Mr Anthony Witherdin
Acting Director
Regional Assessments
Department of Planning and Environment
GPO Box 39
Sydney NSW 2001

Section 96 (1A) Modification, One Carrington, Sydney (SSD 5824 MOD 1)

Thank you for your letter dated 19 November 2015 requesting Transport for NSW (TfNSW) comment on the above modification proposal.

DRAWINGS  
L-000 COVER SHEET  
L-100 PUBLIC DOMAIN CONCEPT PLAN  
L-110 PUBLIC DOMAIN MATERIALS

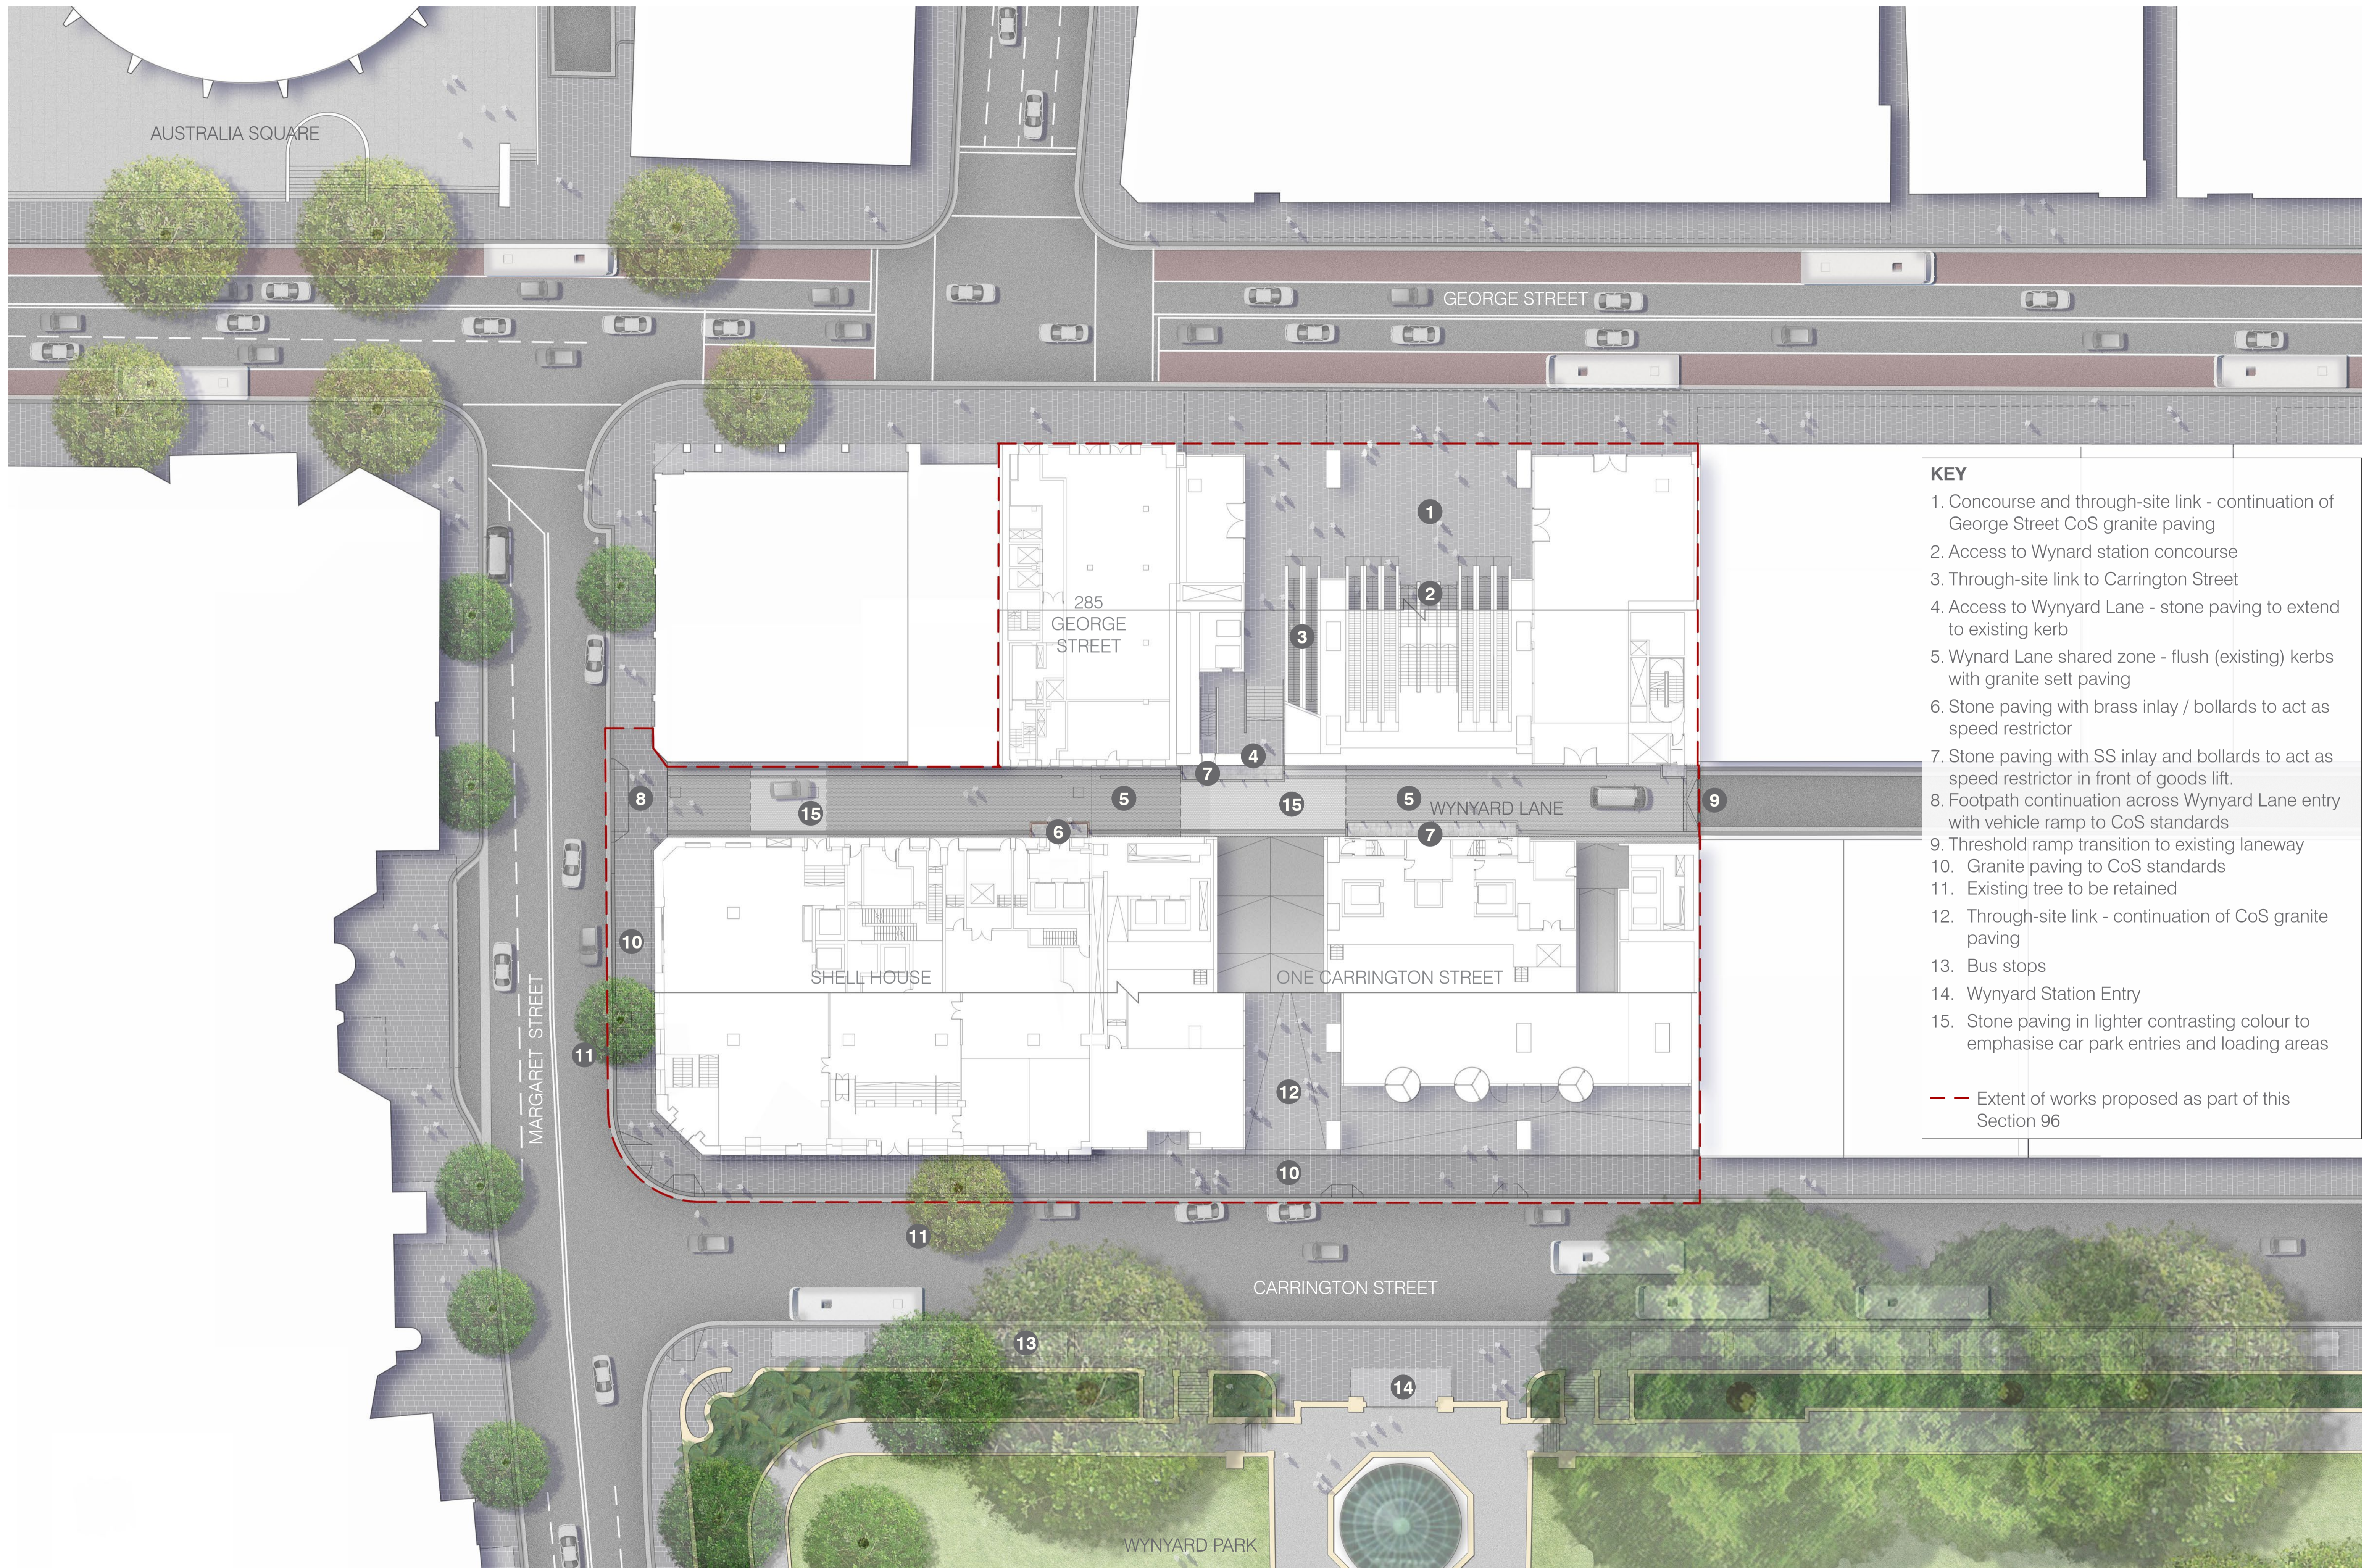
The Public Domain Concept Plan (PDCP) prepared as part of the modification proposal includes stone paving with brass inlay/bollards to act as a speed restrictor. The proposed arrangement is not supported by TfNSW due to the following reasons:

- The proposed arrangement would guide vehicles to travel along the eastern side of Wynyard Lane. As a result of this, pedestrians entering Wynyard Lane opposite to the applicant's car park access from the east would step into the path of oncoming vehicles. Therefore, there is a potential conflict between pedestrians entering Wynyard Lane and the vehicles travelling along Wynyard Lane.
- The proposed stone paving with brass inlay/bollards area located south of Margaret Street on Wynyard Lane may have the potential to restrict the turning path of the vehicles accessing the loading bay for the proposed development at 275-281 George Street.

Based on the above, TfNSW requests that the applicant demonstrates the proposed stone paving with brass inlay/bollards along Wynyard Lane would not have impact on the proposed development at 275-281 George Street and the pedestrian safety along Wynyard Lane.

The PDCP shows that pedestrians enter Wynyard Lane from the east opposite the car park access for the proposed development where multiple vehicle movements will occur. This arrangement would have the potential to cause pedestrian/vehicle conflicts and is likely to increase pedestrian related incidents at this location. TfNSW requests that the applicant demonstrates the proposed arrangements at the car park access would not cause pedestrian related incidents.

The PDCP shows a narrow car park entry and a ramp to the public car park. It should be noted that the public car park access needs to include the vehicle entry lane as well as a pedestrian path. This would enable public to access the car park. It is not clear from the documentation prepared as part of the modification proposal whether the proposed public car park entry accommodates vehicle as well as pedestrian movements. TfNSW requests that the applicant demonstrates the width and gradient of the car park entry cater for vehicles as well as pedestrians in accordance with relevant standards.

The proposed activation of Wynyard Lane has some safety concerns due to multiple vehicle movements with limited sight distances from driveways along Wynyard Lane. TfNSW requests that a Stage 2 (Concept Design) road safety audit be undertaken for the proposed Wynyard Lane works in accordance with *Austroads Guide to Road Safety Audit Part 6: Road Safety Audit* by an independent TfNSW accredited road safety auditor. Based on the results of the Road Safety Audit, the applicant may need to modify their proposal for Wynyard Lane.
